# STERLING RANCH SKETCH PLAN AMENDMENT

SKP-22-004

# Sketch Plan Drawing(s)\_v1.pdf Markup Summary 8-15-2022

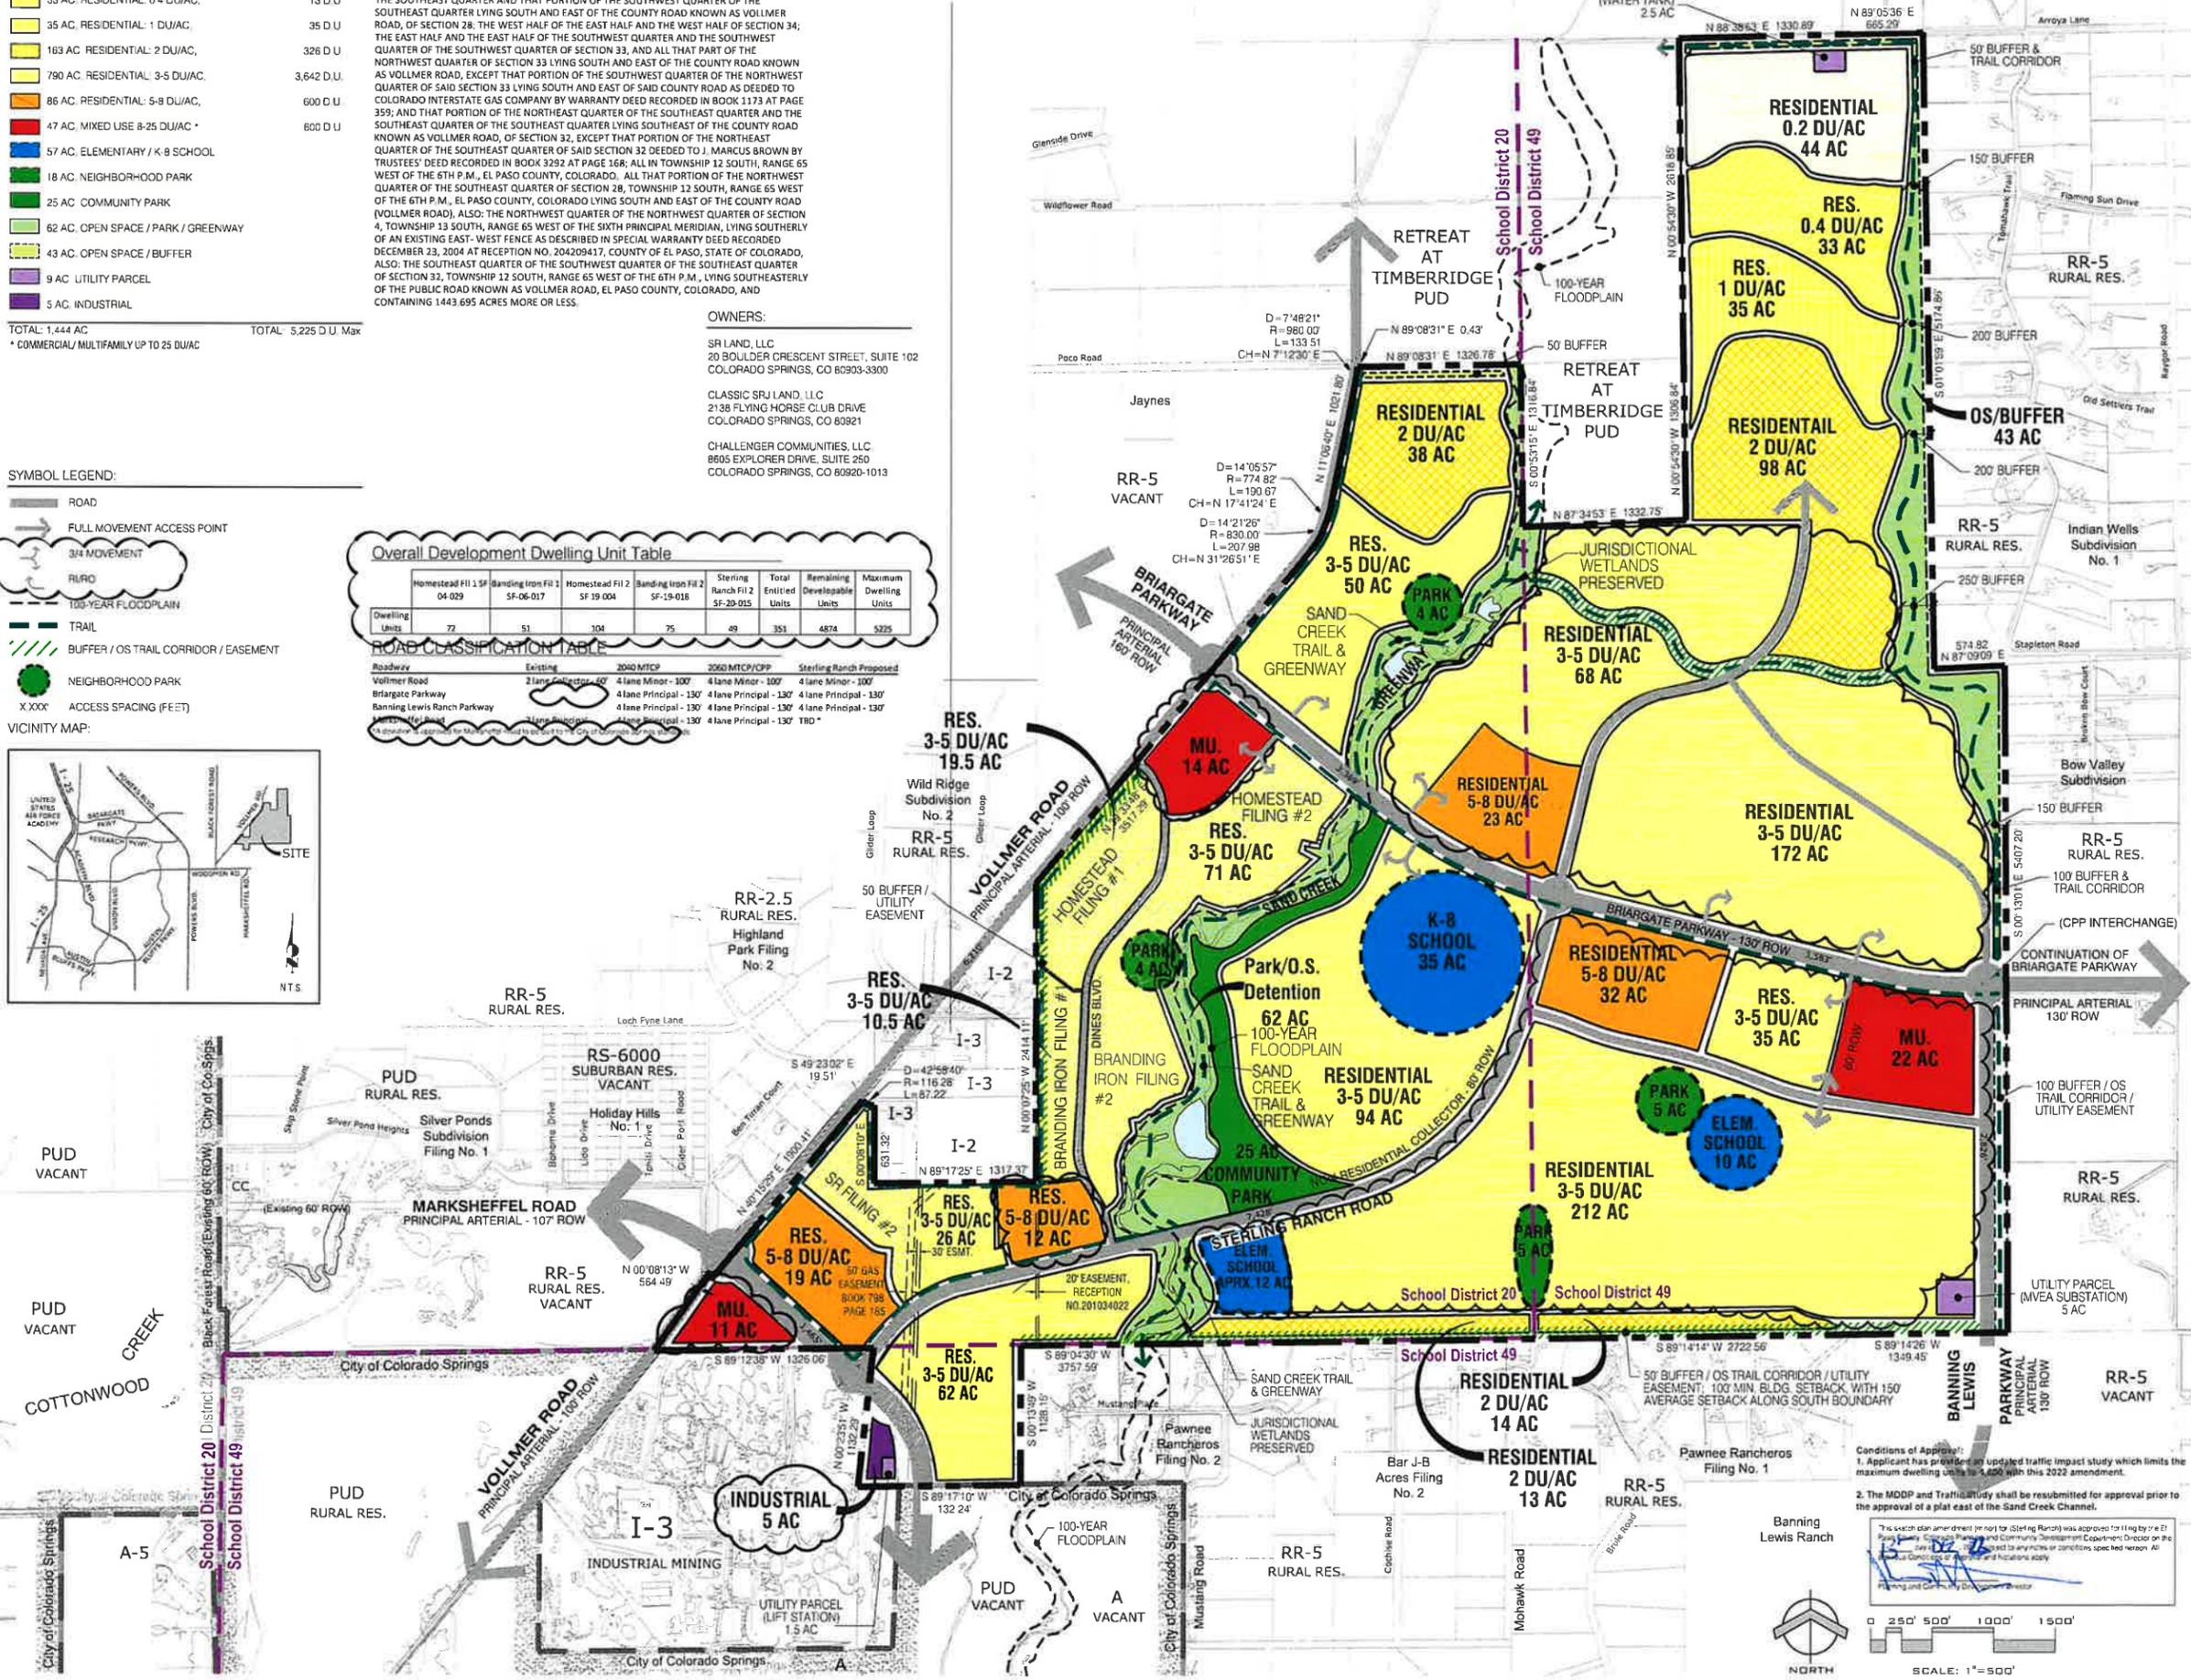
Provide a different symbol for proposed limited access and show on the plan

I don't see these

is part of this commercial proposed now?

part multi-family?

I think this is changing per FAWWA tank plans per JDS Hydro; Cloud changes areas per LI change is proposed here.
